Our Ref: TR020005

Date: 9 May 2024

**Application by Gatwick Airport Limited for an Order Granting Development Consent
for the Gatwick Airport Northern Runway Project**

Request for further information and written comments

Figure 1.2 Baseline, Passengers (m)

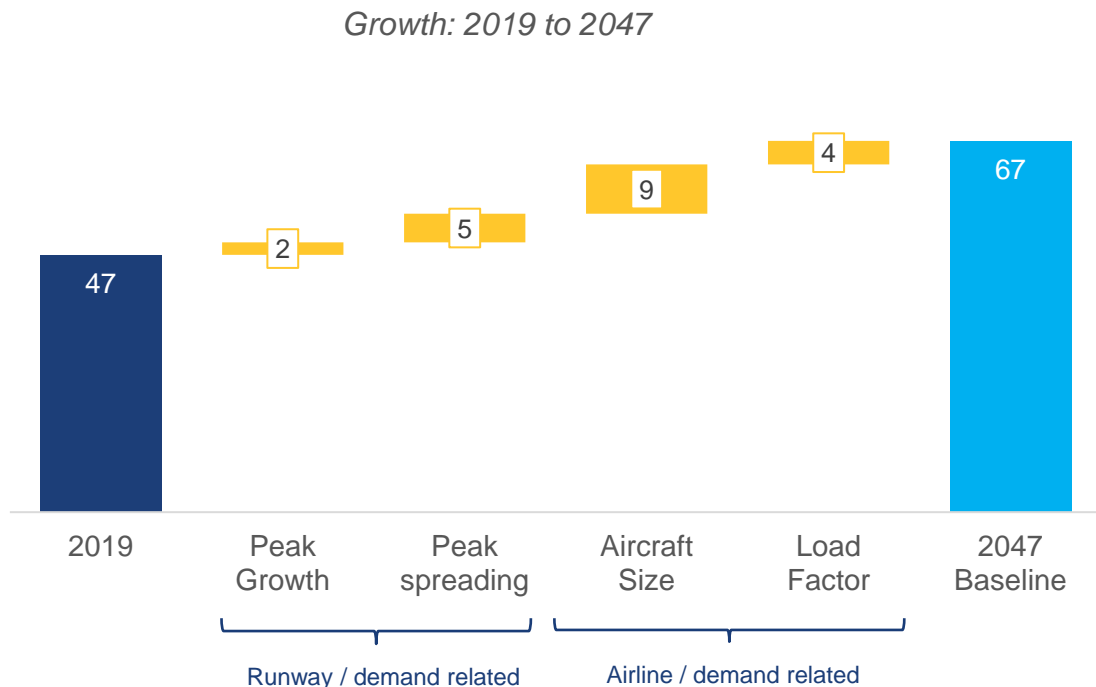
R17b	Question to:	Question:
		<p>d) Figure 1.2 of [REP1-047] details the breakdown of the various growth sectors that constitute the future baseline. These are categorized in the table into two areas: runway/demand related (peak growth and peak spreading) and airline/demand related (aircraft size and load factor). Is there or could there be an element of double counting in such figures? For example, would some of the stated 5mppa growth attributable to peak spreading in the table also be counted within the 9mppa growth allocated for aircraft size as some of the aircraft using the runway at off peak times may be the larger aircraft stated to make up the aircraft size category?</p>
R17b. 2	The Applicant	<p>Waste Management Assessment</p> <p>1. In response to ExQ1 RES.1.2, the Applicant incorrectly stated that the assessment of waste impacts was scoped out of the Environmental Impact Assessment in the Scoping Opinion provided by the Planning Inspectorate [APP-095]. The Inspectorate agreed that waste arising from the extraction, processing and manufacture of the construction materials and components could be scoped out of the assessment (ID 4.13.1 of the scoping tables). However, this does not cover the waste arising from the construction processes required for the Proposed Development or waste arising from the operational phase.</p> <p>To demonstrate compliance with the EIA regulations Schedule 4 Paragraph 5(c), the Applicant is asked to either:</p> <ol style="list-style-type: none"> a. provide a description of likely significant effects resulting from the creation, disposal and recovery of waste; or b. justify why an assessment of likely significant effects has not been undertaken for waste impacts, other than those agreed to be scoped out, by demonstrating that the Proposed Development would result in no likely significant effects. <p>2. The EIA regulations state that the description of the development should include an estimate, by type and quantity, of types of waste produced during the construction and operation phases (Schedule 4 Paragraph 1(d)). In relation to construction waste, the ExA note that the Applicant, provides approximate quantities of excavated materials, including potentially</p>
